April 17, 2020

El Paso County Development Services Department  
Attn: Jeff Rice / Steve Kuehster, PCD-Engineering  
2880 International Circle  
Colorado Springs, CO 80910

**SUBJECT: Comment Response Letter (SF-19-014)  
Bent Grass Residential Filing No. 2 Sixth Submittal**

BENT GRASS RESIDENTIAL  
FILNG No. 2 PUD  
FINAL LANDSCAPE PLAN

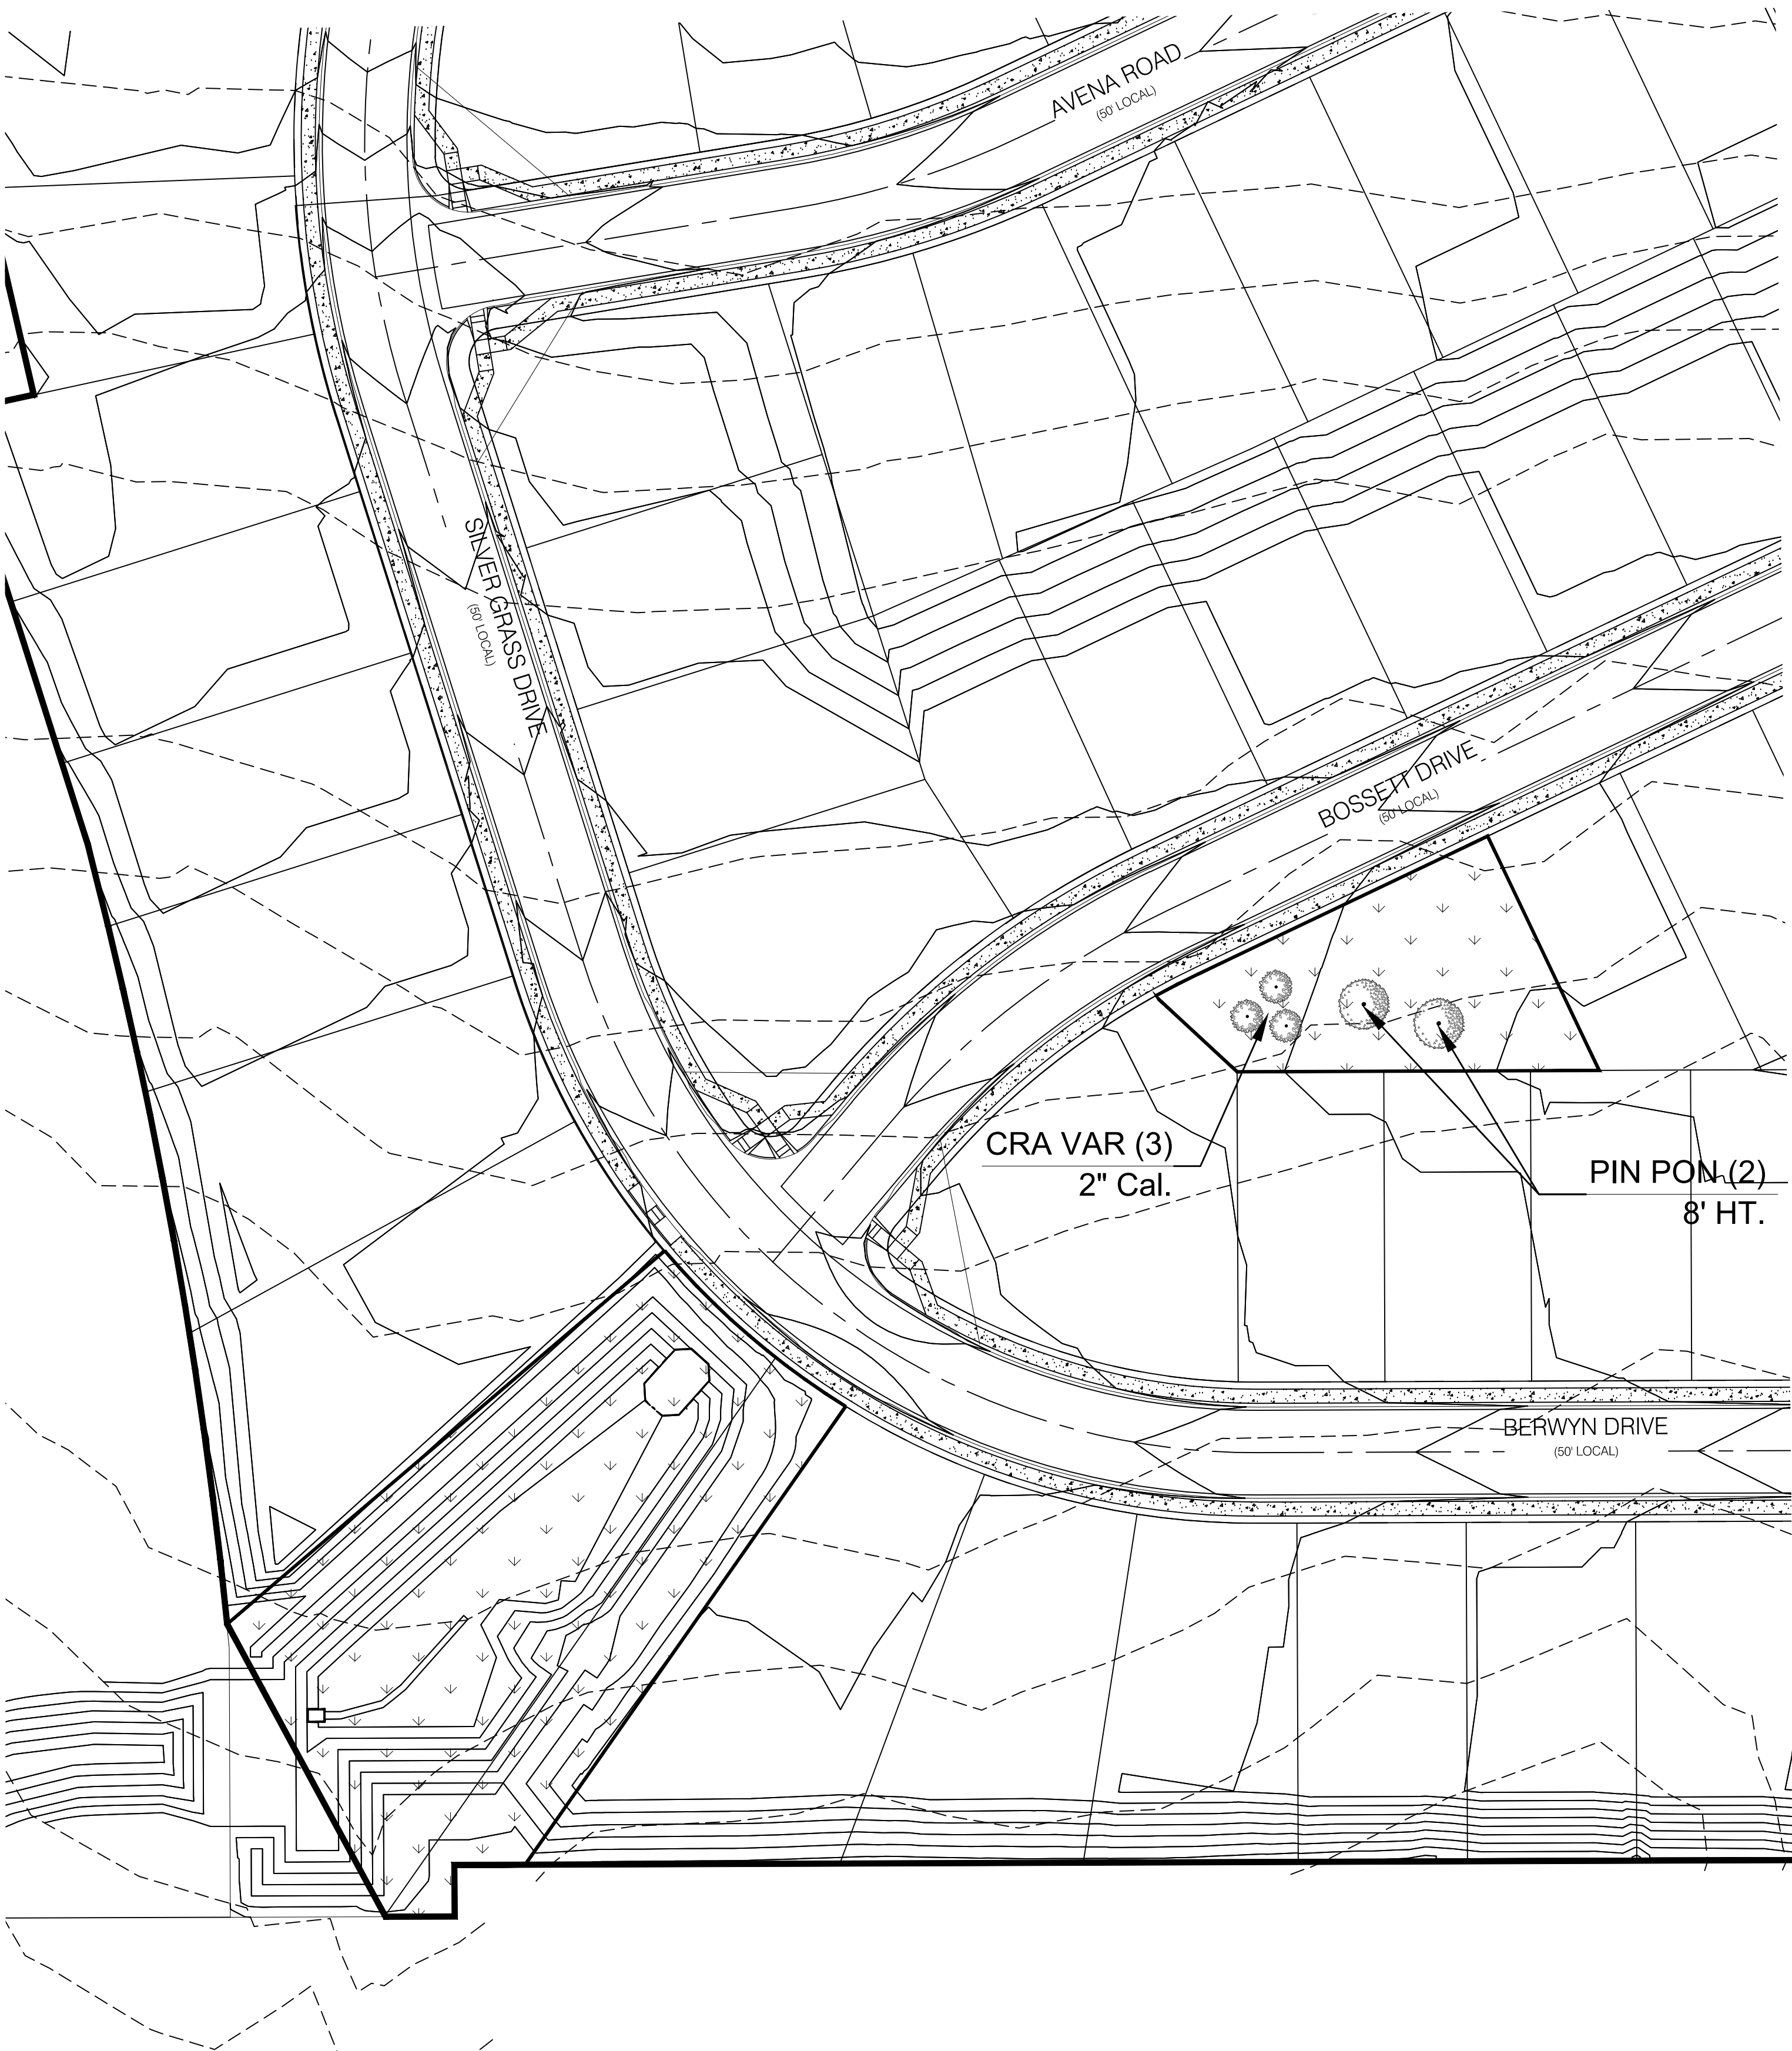
5. Note: A license agreement will be required for landscaping in the Bent Grass Meadows Drive ROW.
  - a. **A redline was previously provided on the landscaping plan to address pedestrian sight distance on the north side of Bent Grass Meadows at the ramp where pedestrians cross toward Lemon Grass Road. It appears that the landscape plan has been revised, but a sight distance line was not found on the plan; please show the line on the landscape plan.**

**Response: Sight distance line has been added to landscape plan.**
